Our ref: DOC22/244379

Your Ref: SSI-22765520

**Subject: Request for Advice: the Sydney Metro West - Rail infrastructure, stations, precincts and operations (SSI-22765520)**

### Attachment A: Flood risk management comments on Sydney Metro West - Rail infrastructure, stations, precincts and operations (SSI-22765520)

**Figure 13-19 Potential change in flood levels (one per cent AEP event) – The Bays Station**

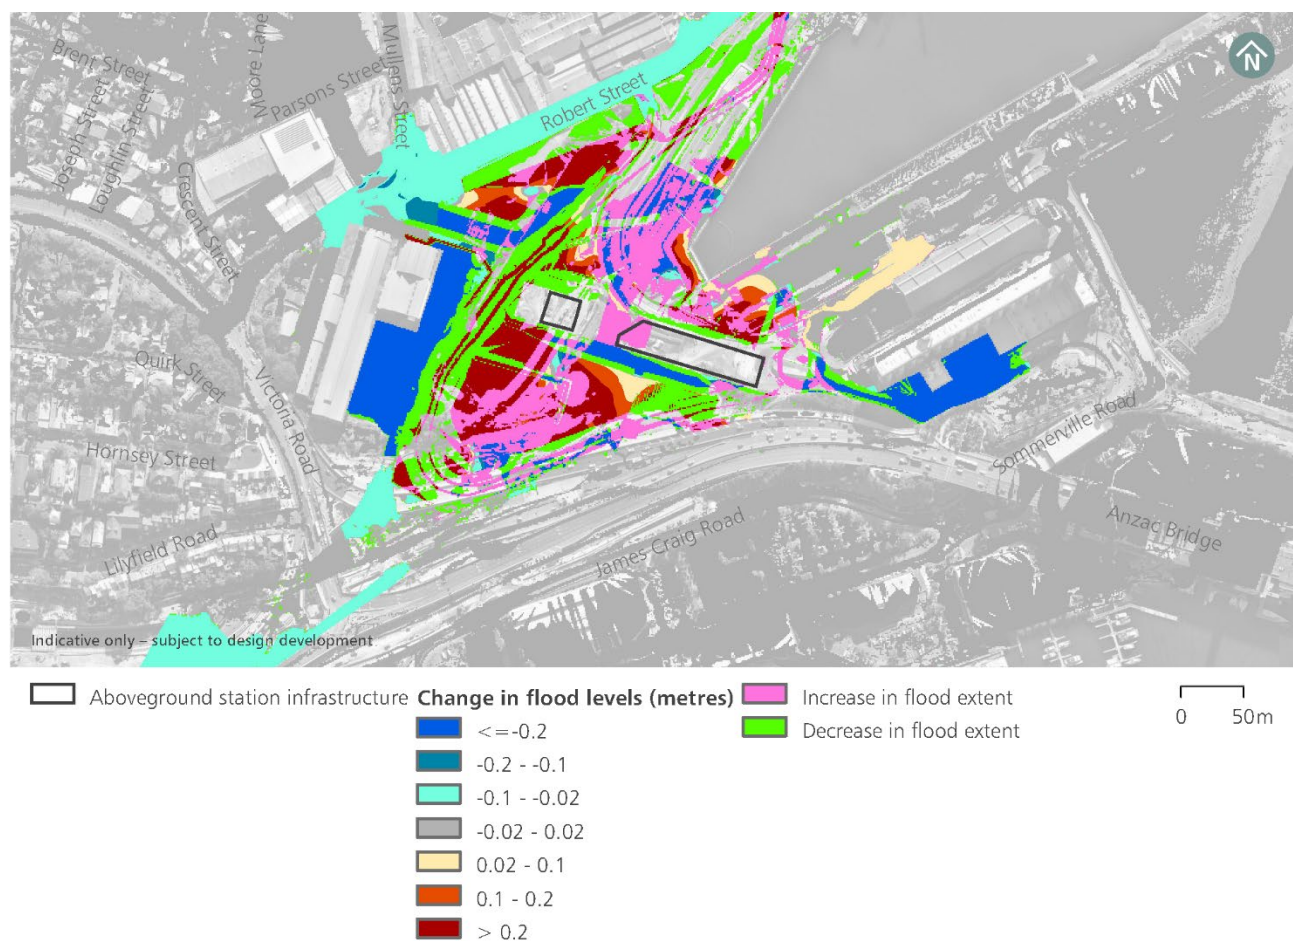
It is not clear whether flood barriers would be required at The Bays Station. The EIS (Chapter 13) indicates that the flood protection level would be higher than the station entry level at The Bays. However, Table 5-16 of the Hydrology Report indicates that the flood level would be lower than the station entry level. These details need to be checked and updated accordingly.

A comprehensive assessment will be required for the development of flood risk management options at The Bays Metro Station, which will be integrated with the Bays West Place Strategy.
